RE: **Lot 18 Block 5 Unit 18 Volcano Cliffs SAD 228**  
**6624 Sujeto NW**  
**Grading and Drainage Plan**  
**Engineers Stamp Date 7/18/17 (D10D003K18)**

Based upon the information provided in your submittal received 7/19/17, this plan cannot be approved for Grading Permit until the following comments are addressed.

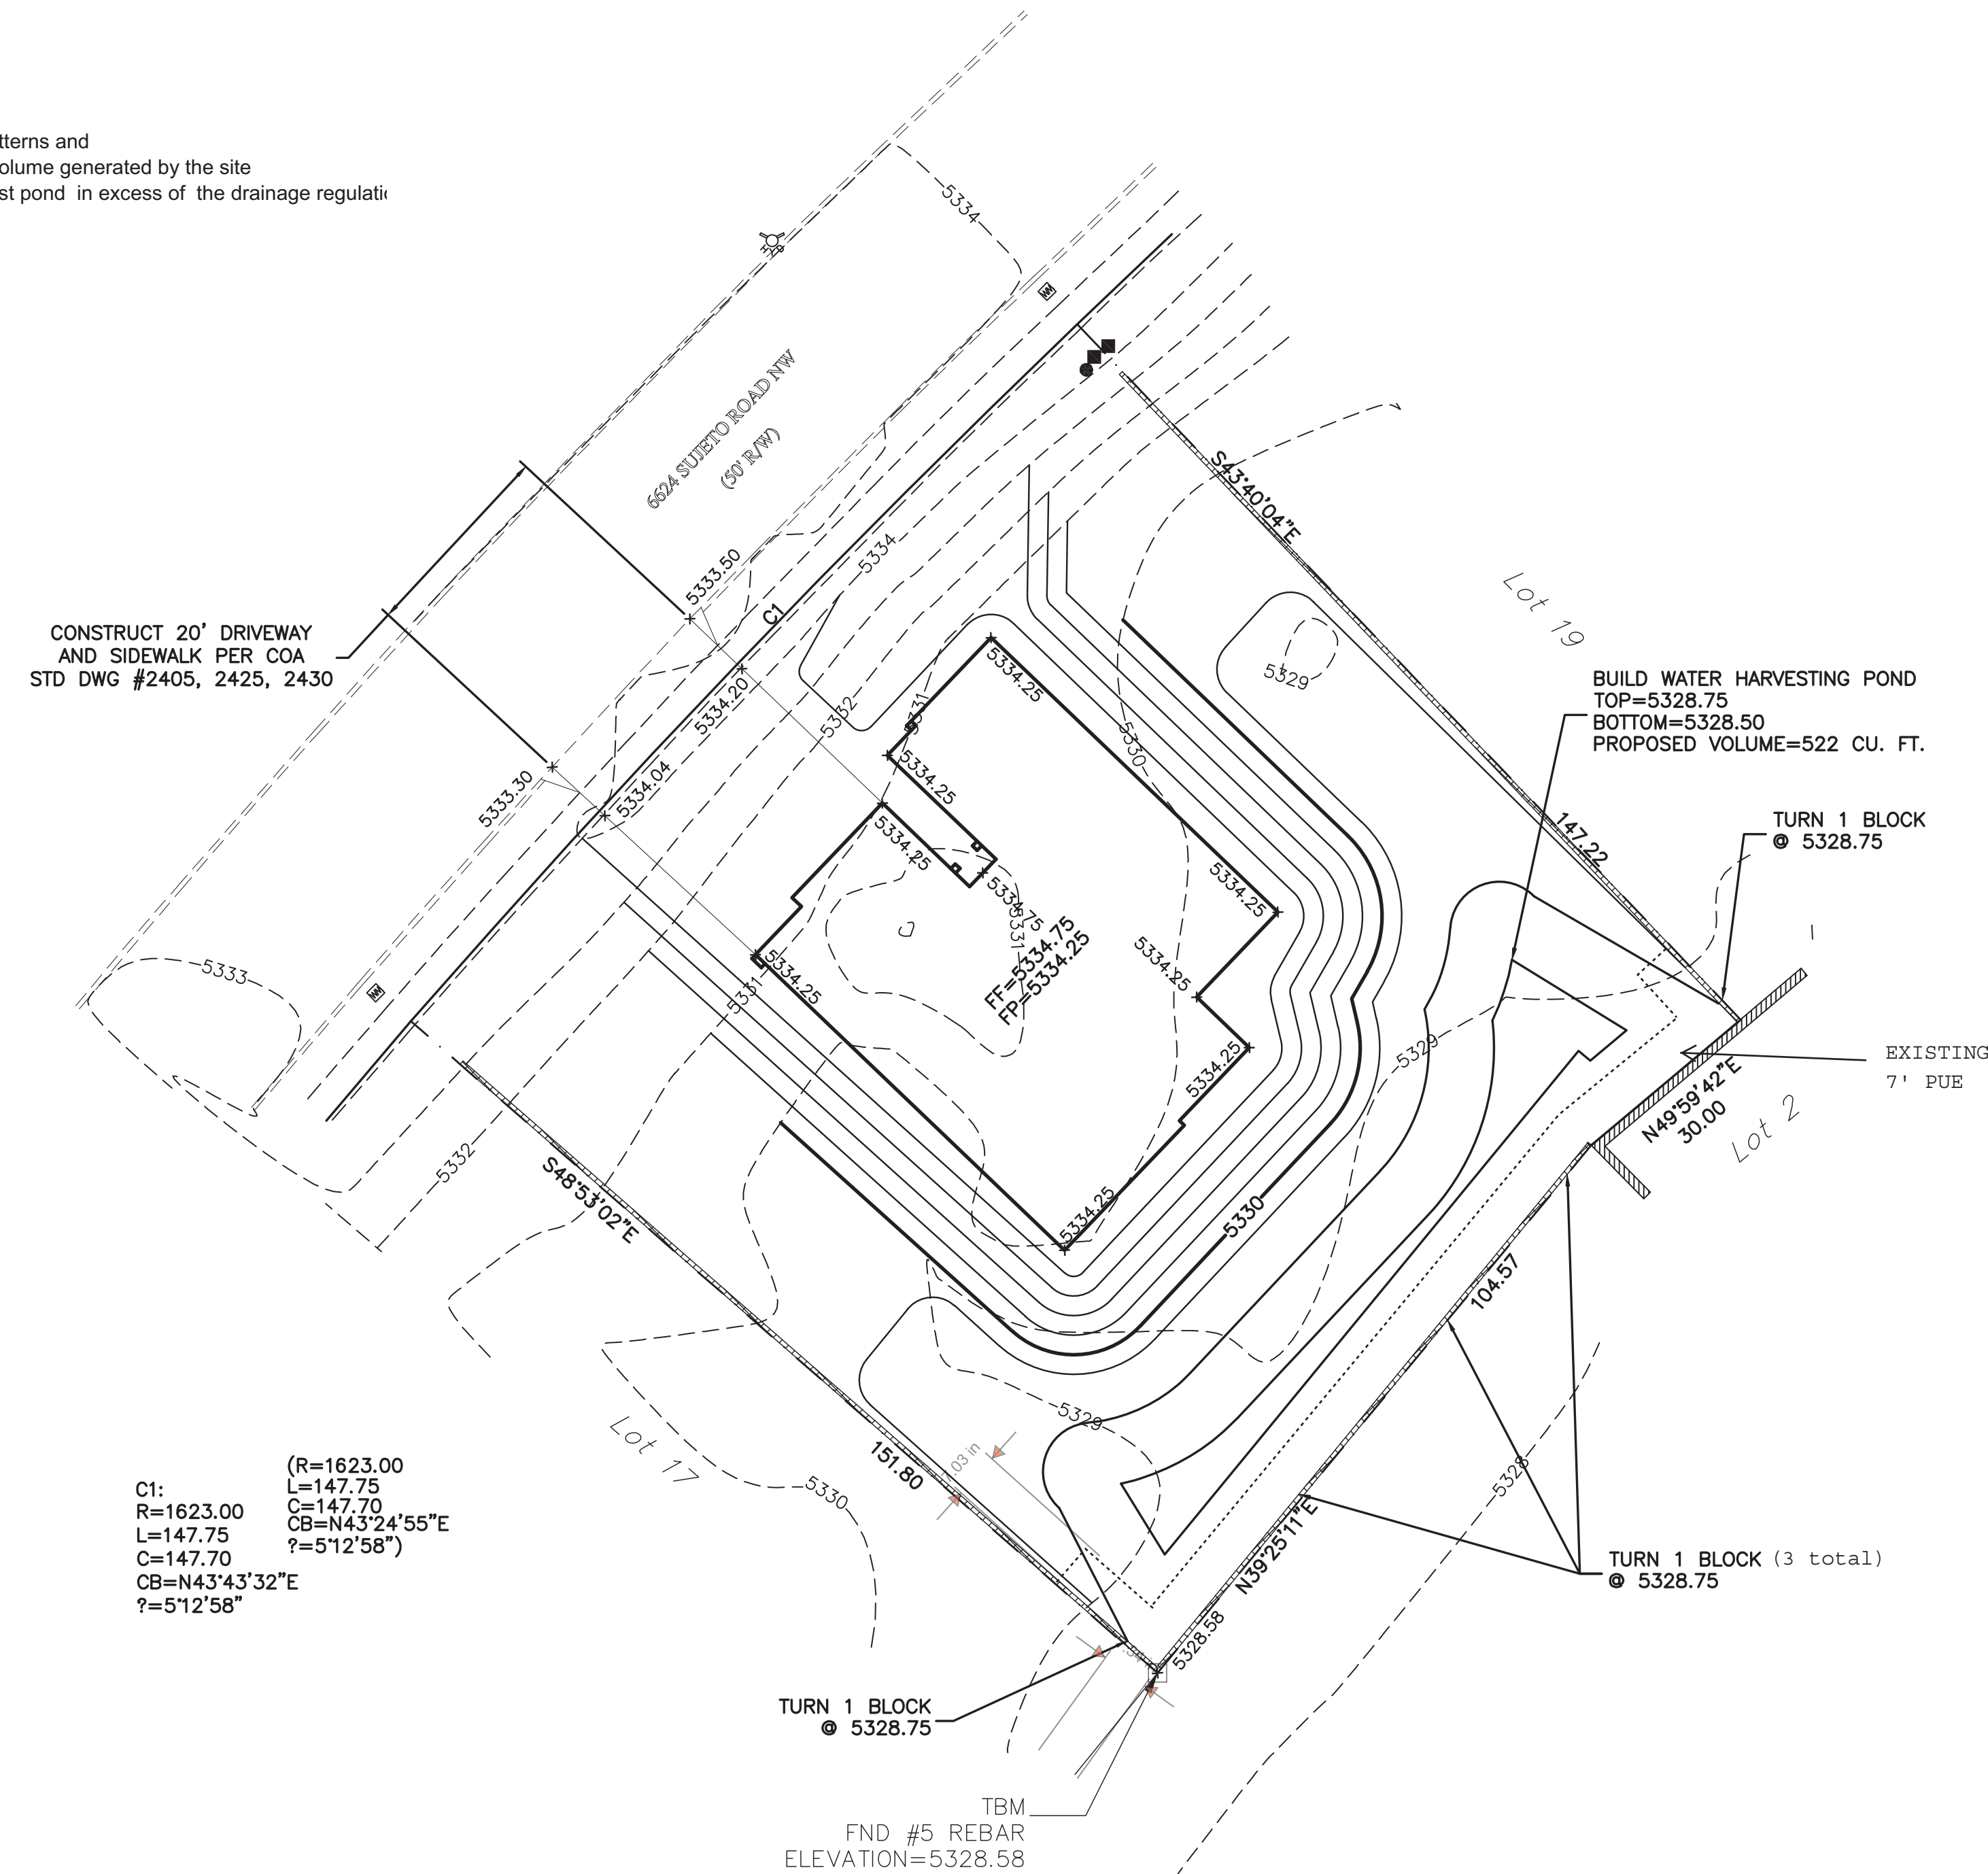
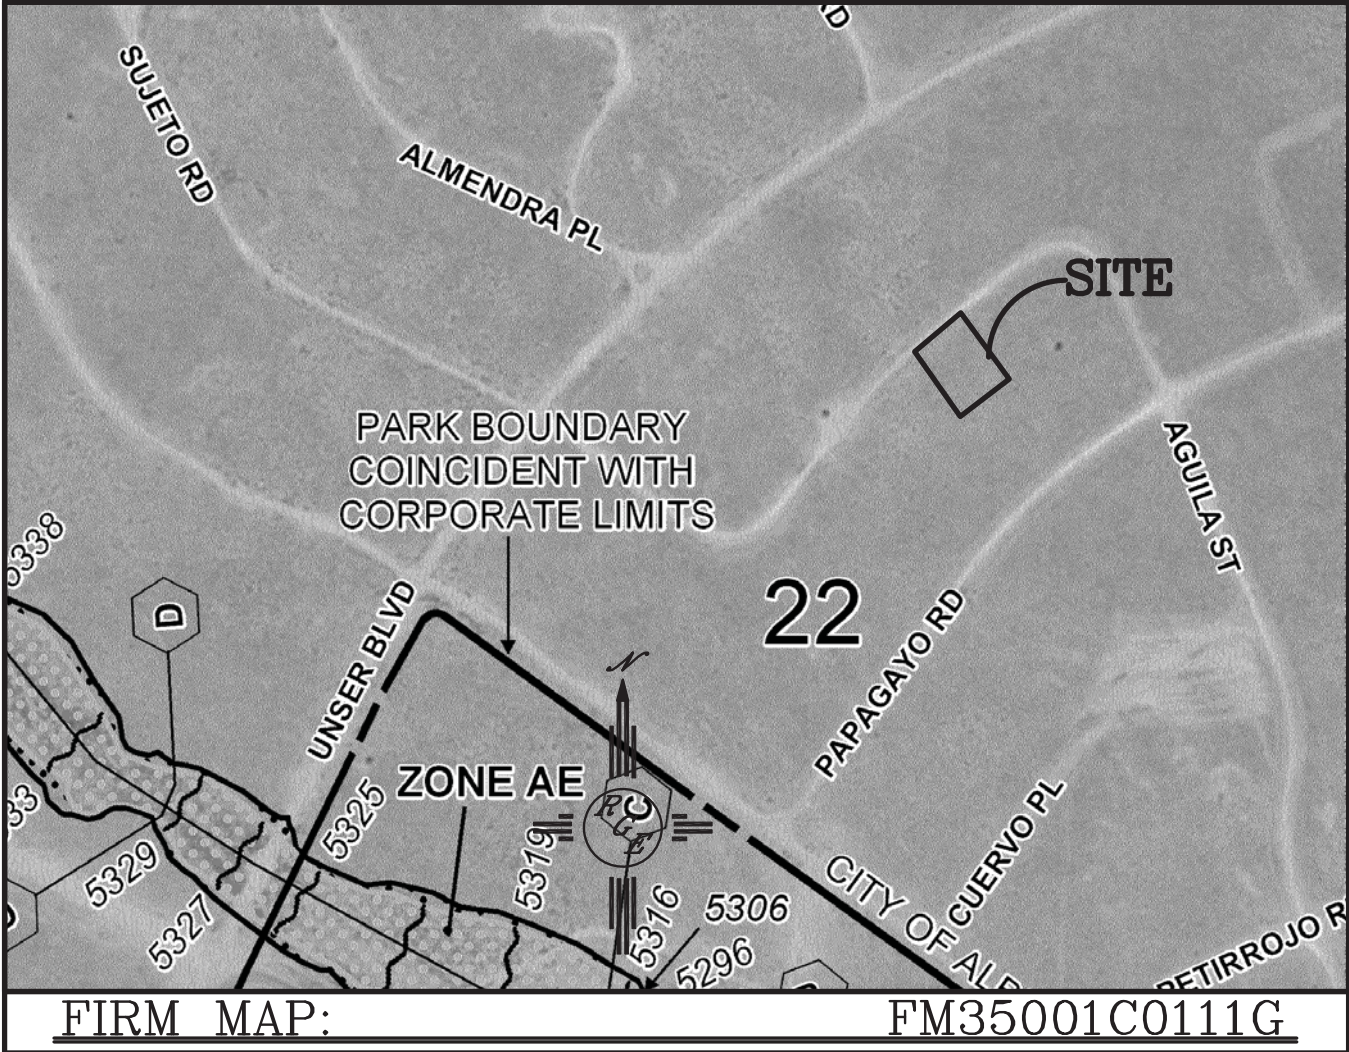
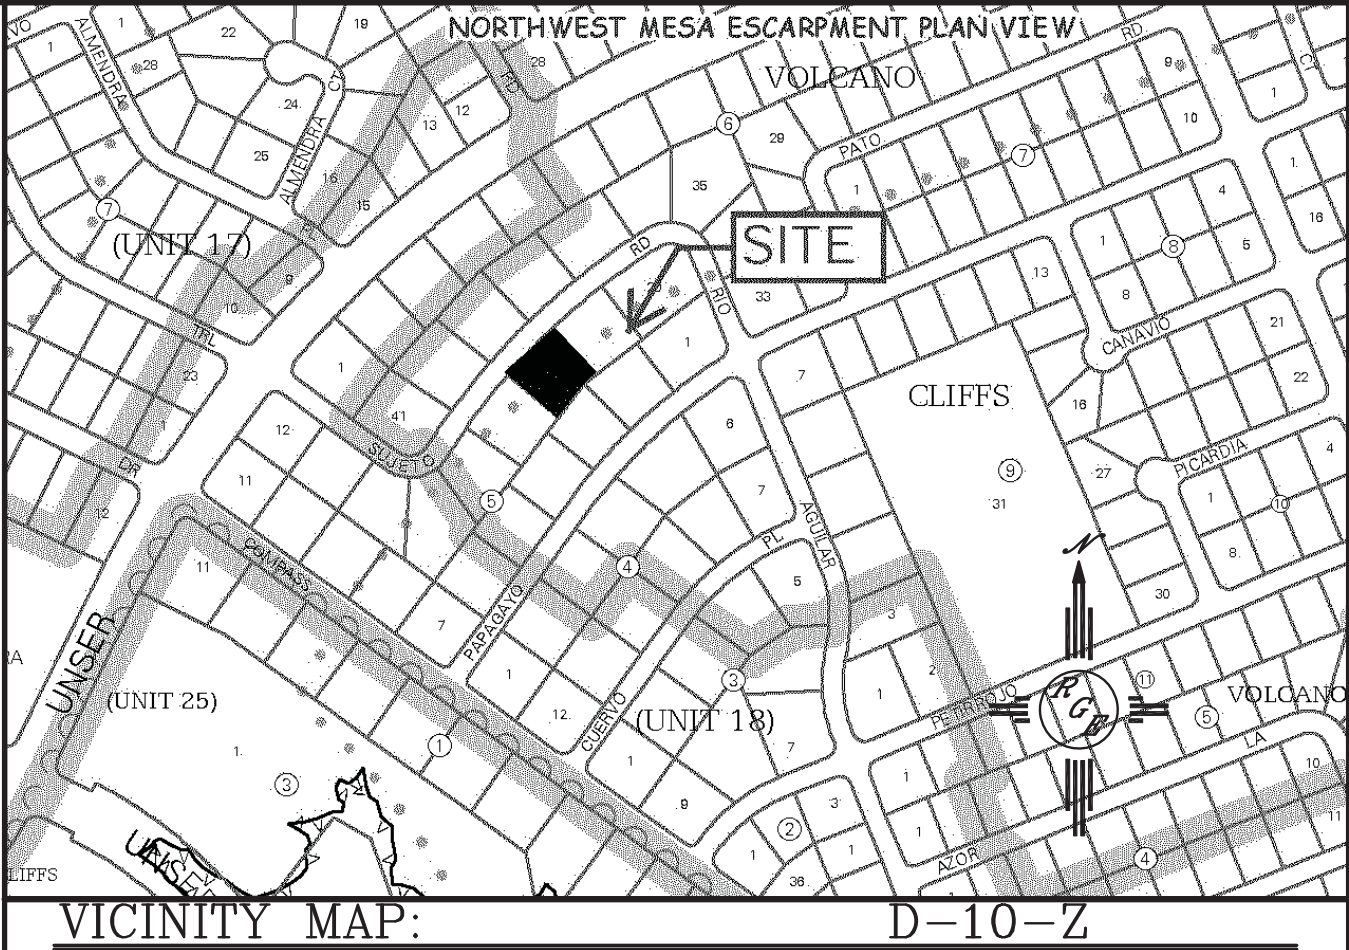
- Provide calculations for the openings in the walls.
- Show the 7 foot P.U.E.
